Our Ref: BR/92/18/HH
Your Ref:

Town & Country Planning Act 1990 (as amended)
Town & country Planning (Development Management Procedure) (England) Order 2015
Application for Planning Permission for Works or Extension to a Dwelling

Development Erection of 1 No. single storey pitched roof detached annexe to rear garden ancillary to main dwelling.

Location 12 Mansfield Road Bognor Regis

SITE LOCATION PLAN 1:1250

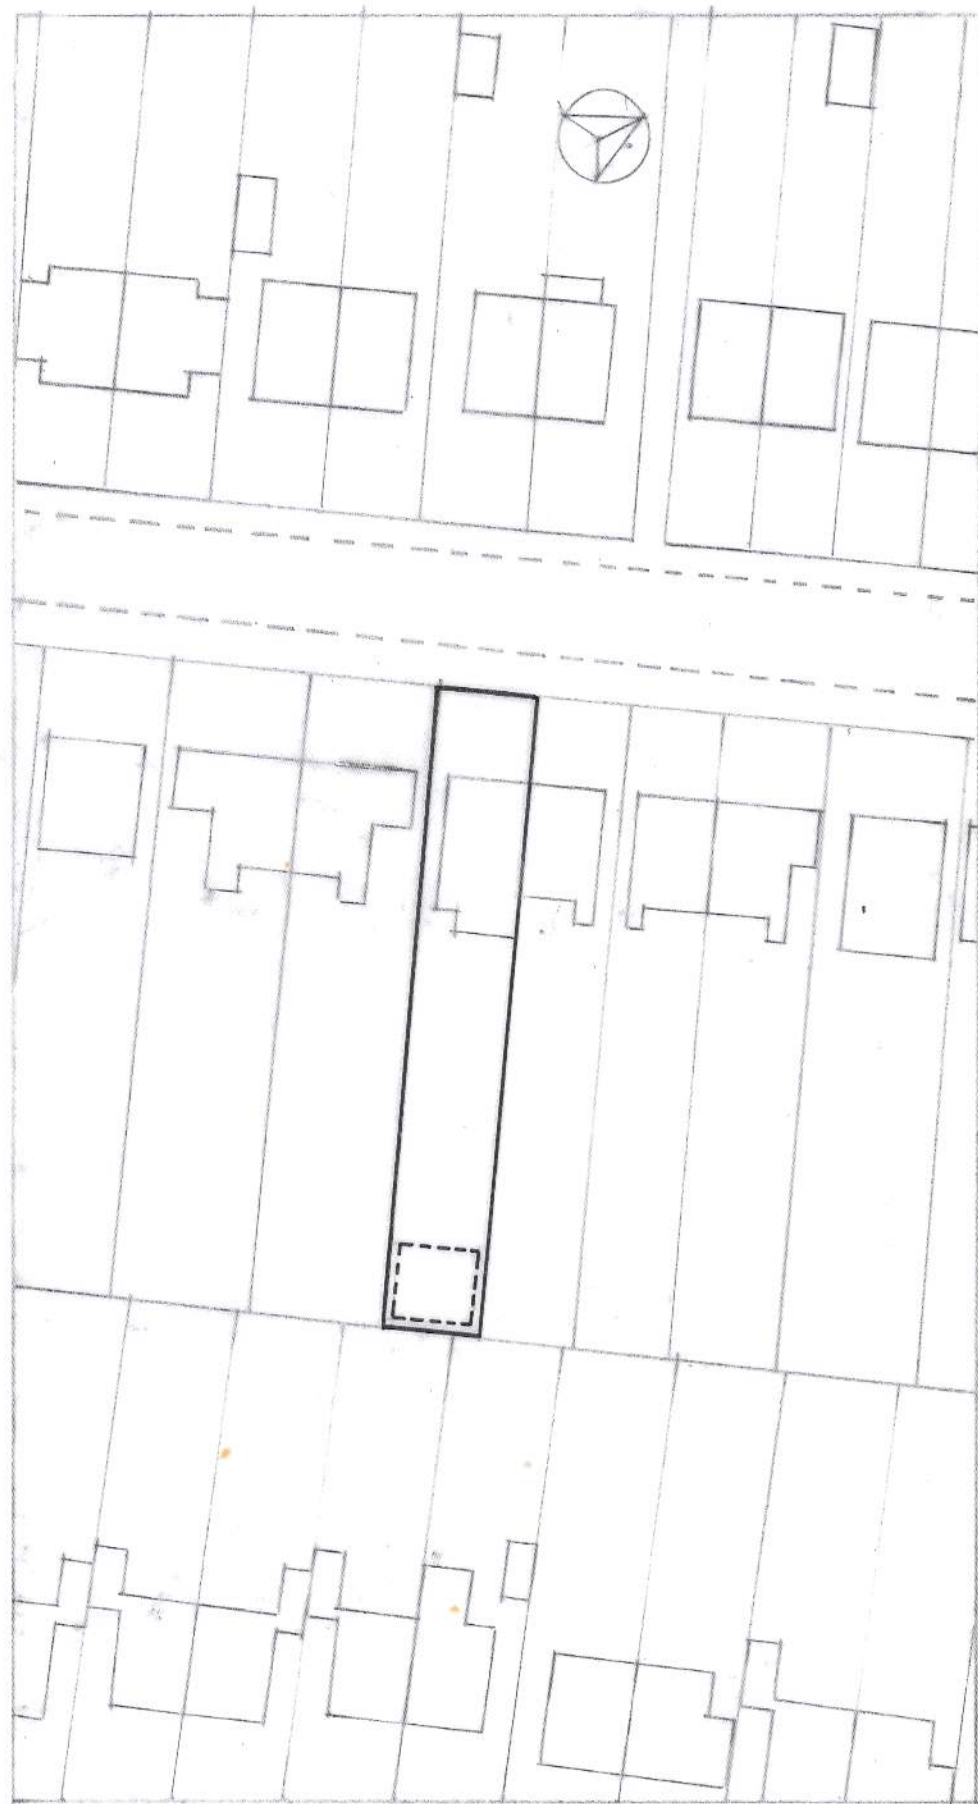
Location Plan Amend

Please submit 1 electronic or 3 paper copies of a location plan at a scale of 1:1250 or 1:2500 for rural areas. Further details of what must be included on the plan can be found in the National Validation Requirements. Please red edge the application site.
